**Consultation Response from KC,
Lead Local Flood Authority**

2022/93154 Land at, Penistone Road, Fenay Bridge, Huddersfield, HD8 0AW

Erection of 68 dwellings with associated access, parking, open space, landscaping and infrastructure works (including installation of surface water attenuation tank)

Date Responded: 5th June 2023

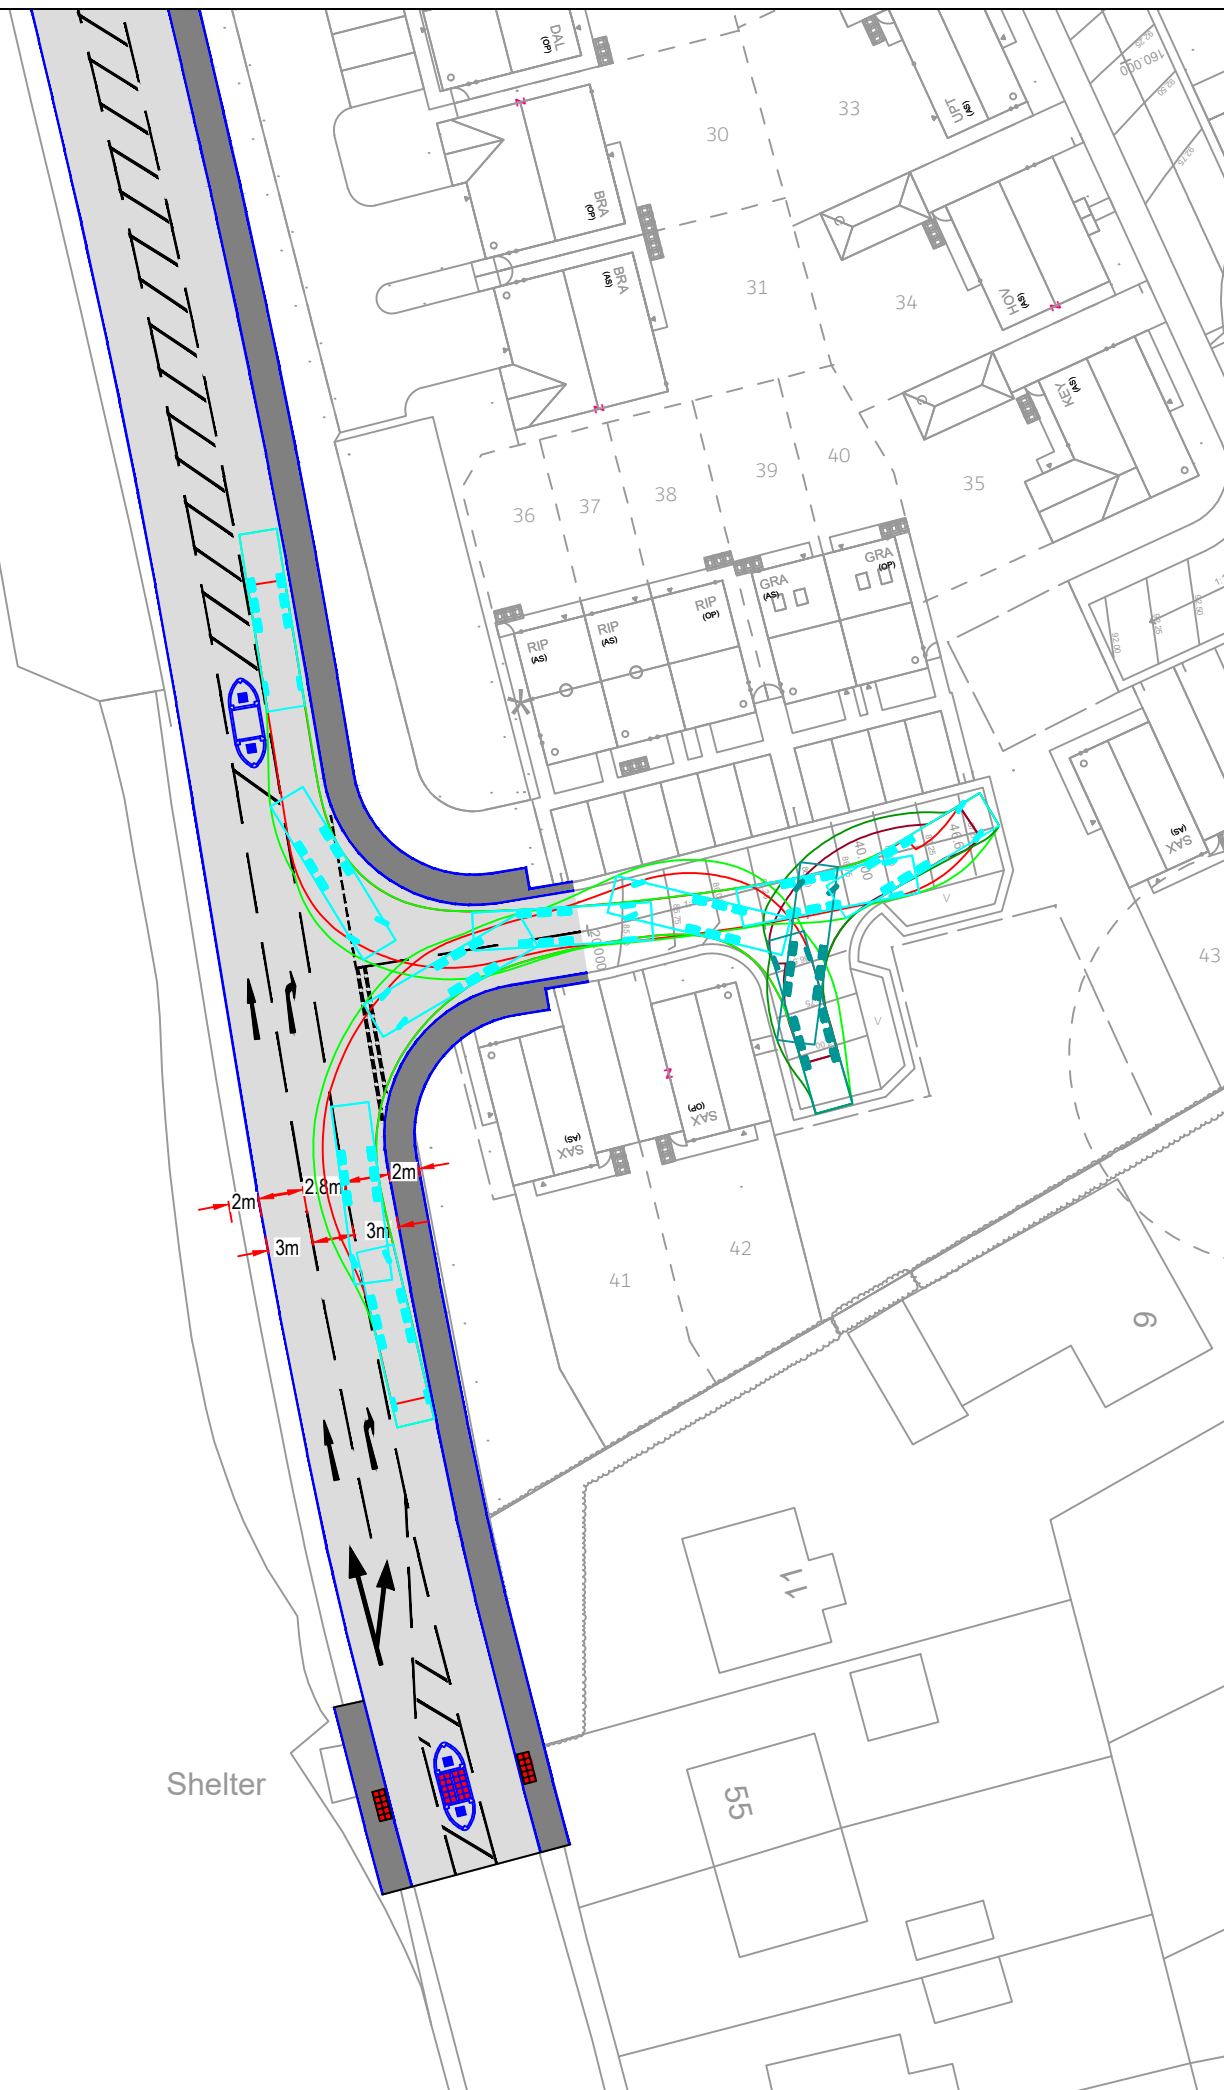
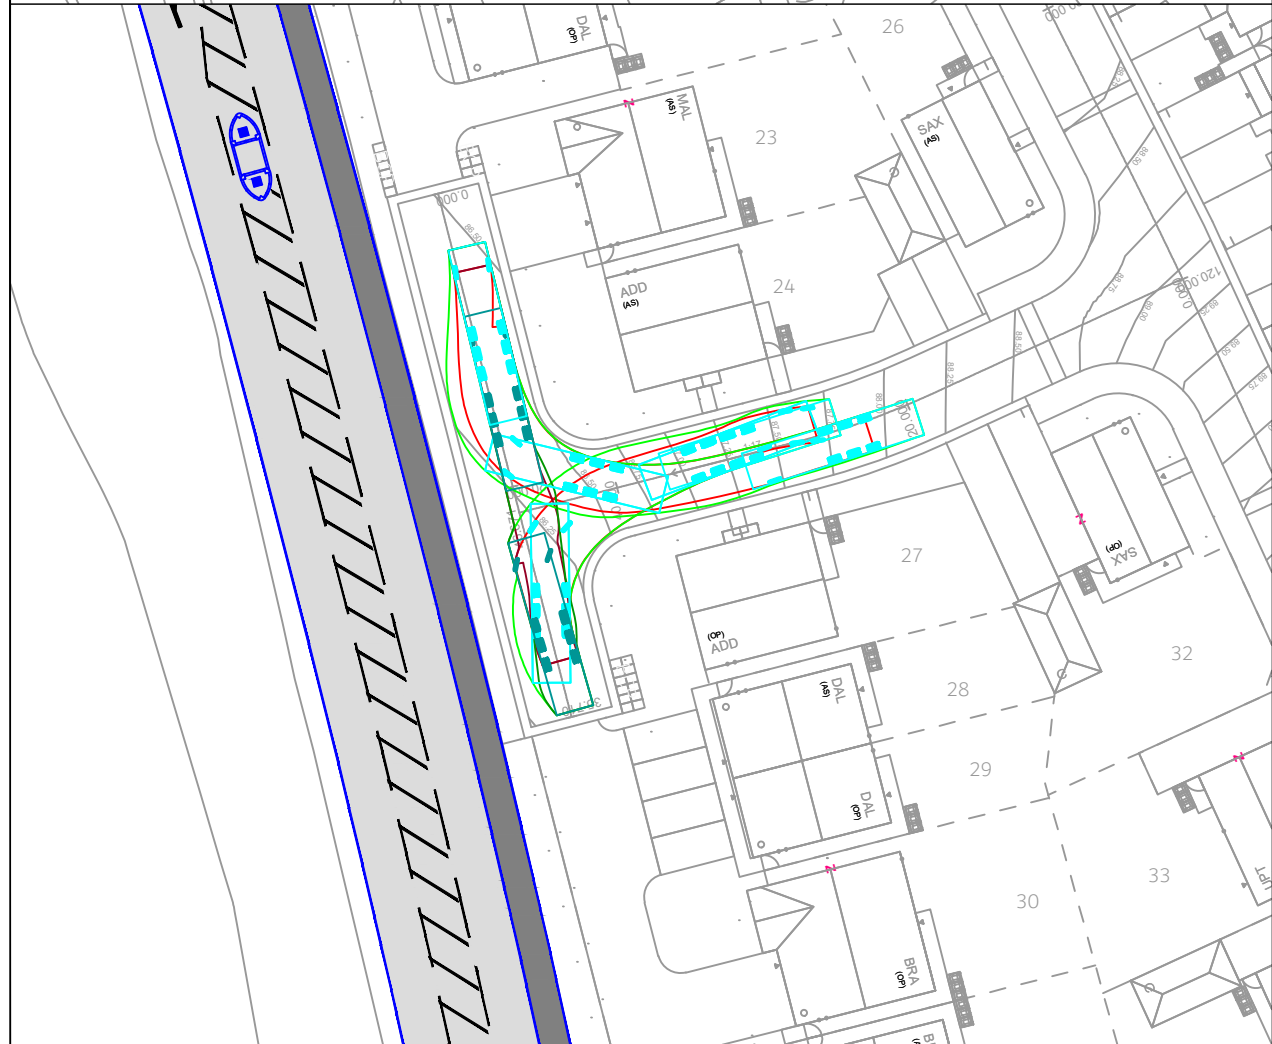
Further to our previous acceptance of this application with appropriate conditions, we would, on light of changes, wish to make sure a highway drain shown discharging to an unknown point in land opposite the site, is fully surveyed and protected from damage from the proposed track and subsequent vehicle loading.
